ITEM 1.5 (c)

**85 Harrington Street
The Rocks
GOLDEN AGE & HANNAS THE ROCKS**

TITLE
**RESPONSE TO DoPE
ITEM 1.5 (c)**

SCALE	1:200 @ A2	PROJECT CODE
DATE	18/7/17	GA85H
SHEET NO.	DA-2030	REVISION
		Q

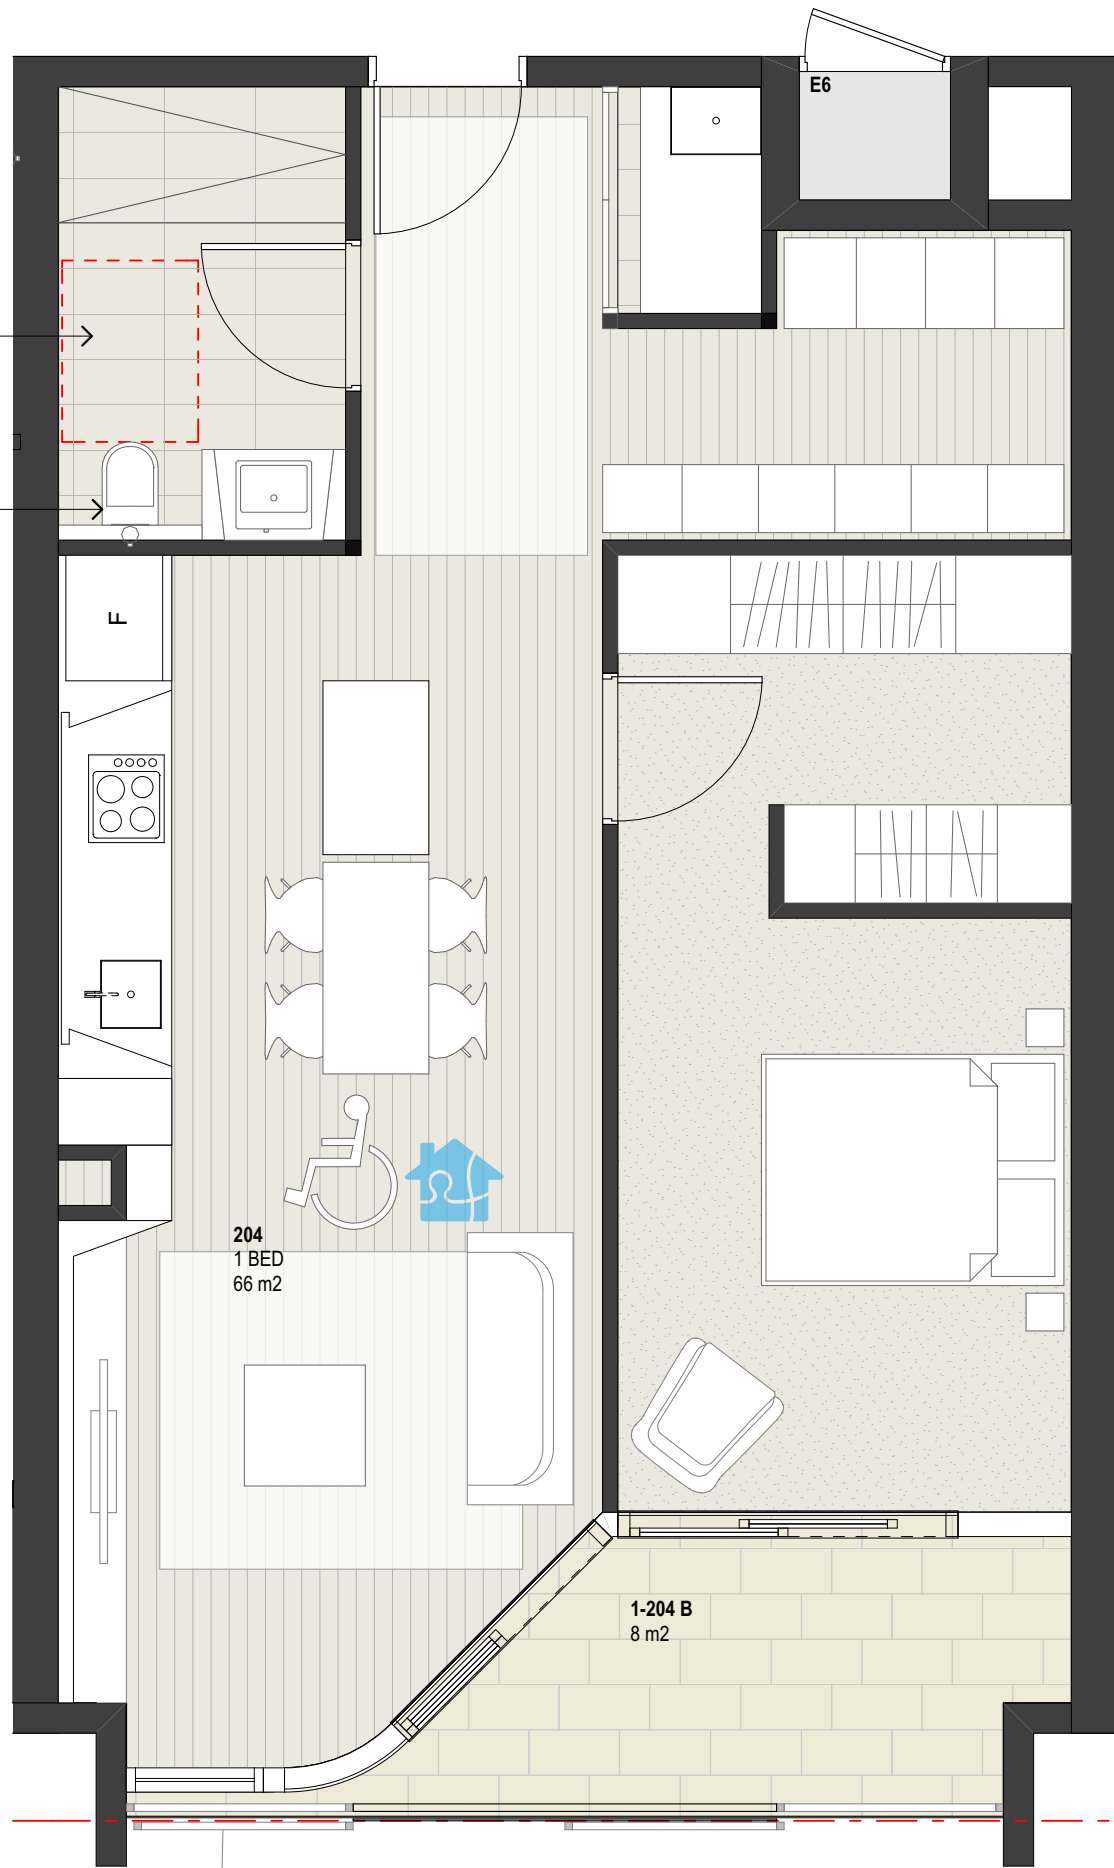
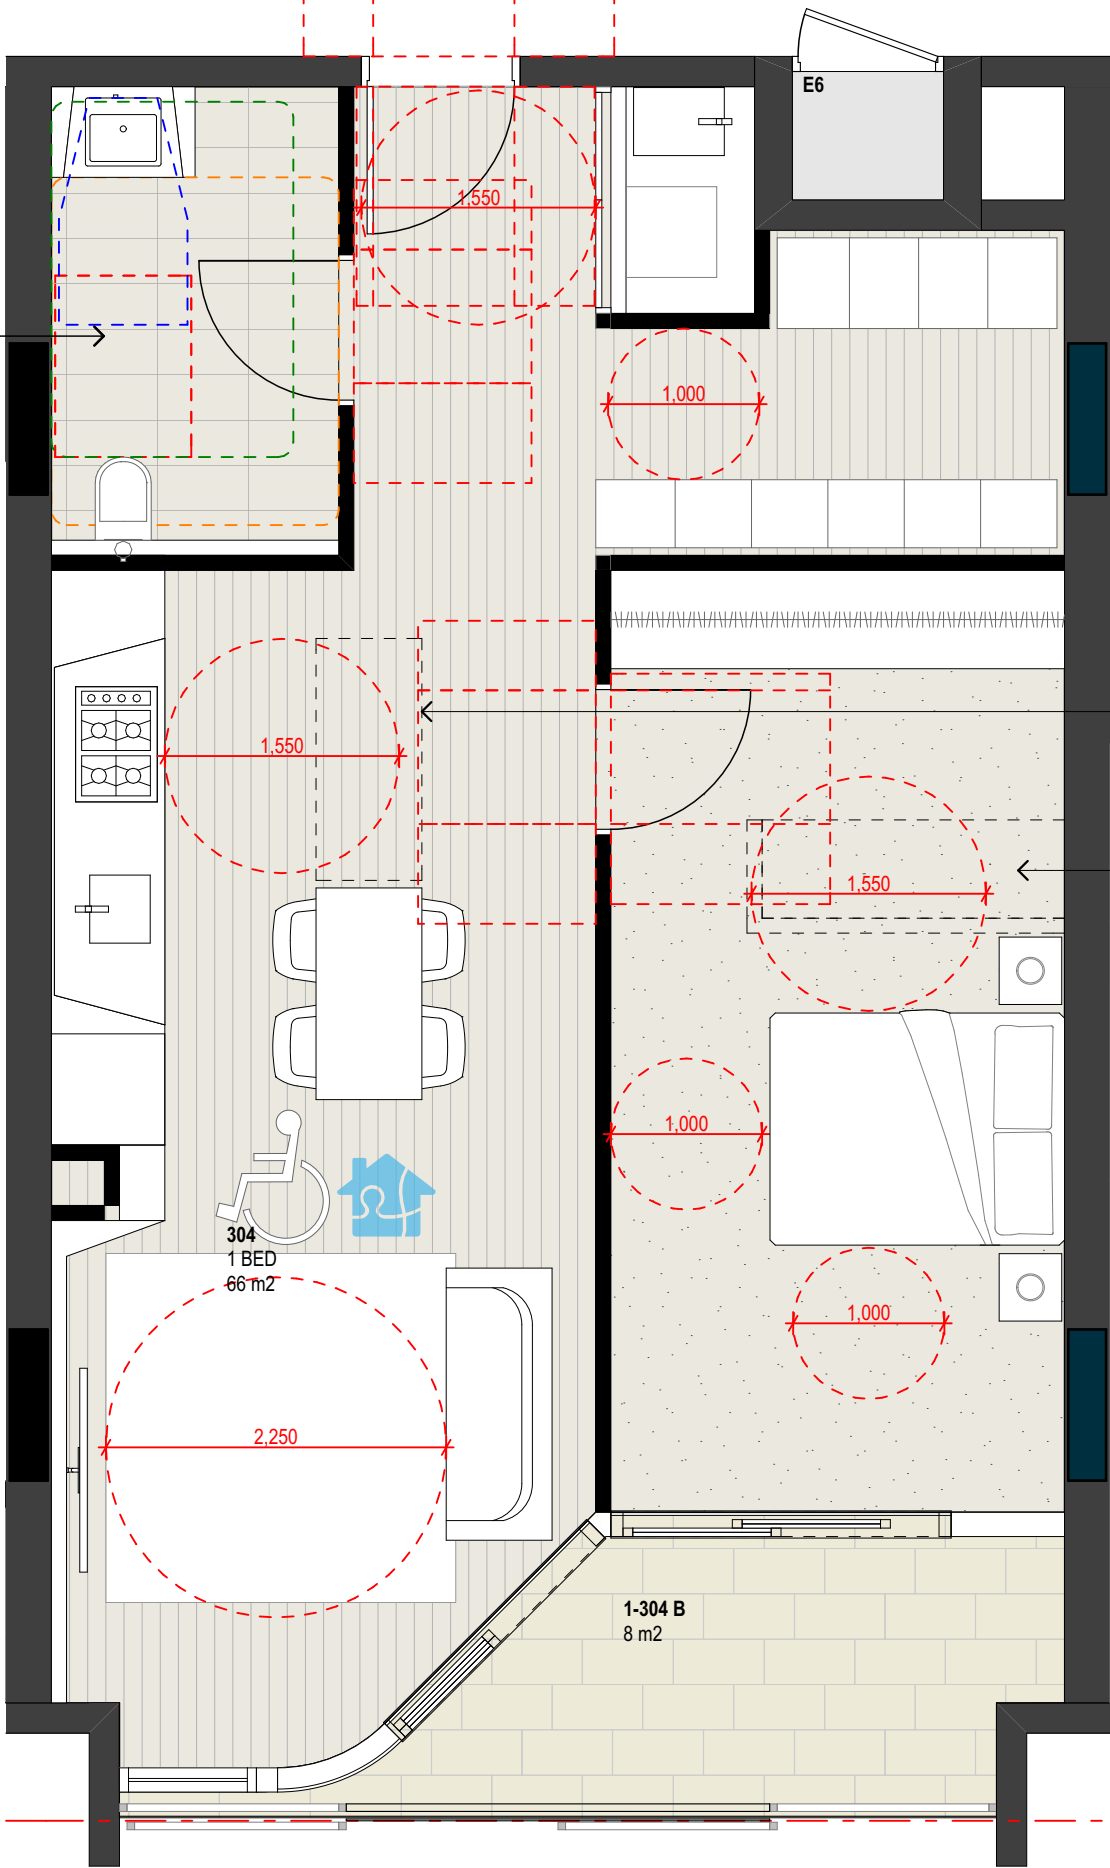
Description:
In addition, Units 204 and above in Building 1 contain a bedroom without a window in an external wall. The Department requests consideration of a revised layout for these units to provide improved amenity for future residents.

Response
Apartment has been revised so the bedroom receives direct daylight and air from an external window.

- The apartment has been amended to ensure that the bedroom receives natural daylight and ventilation from a window in an external wall.
- The area of apartments 204 (and above) are larger than that of the required minimum.
- The apartment offers a large amount of storage for the residents.
- Take into consideration the needs for adaptability for accessible future residents.
- Promotes silver level housing through compliance of liveable housing guidelines
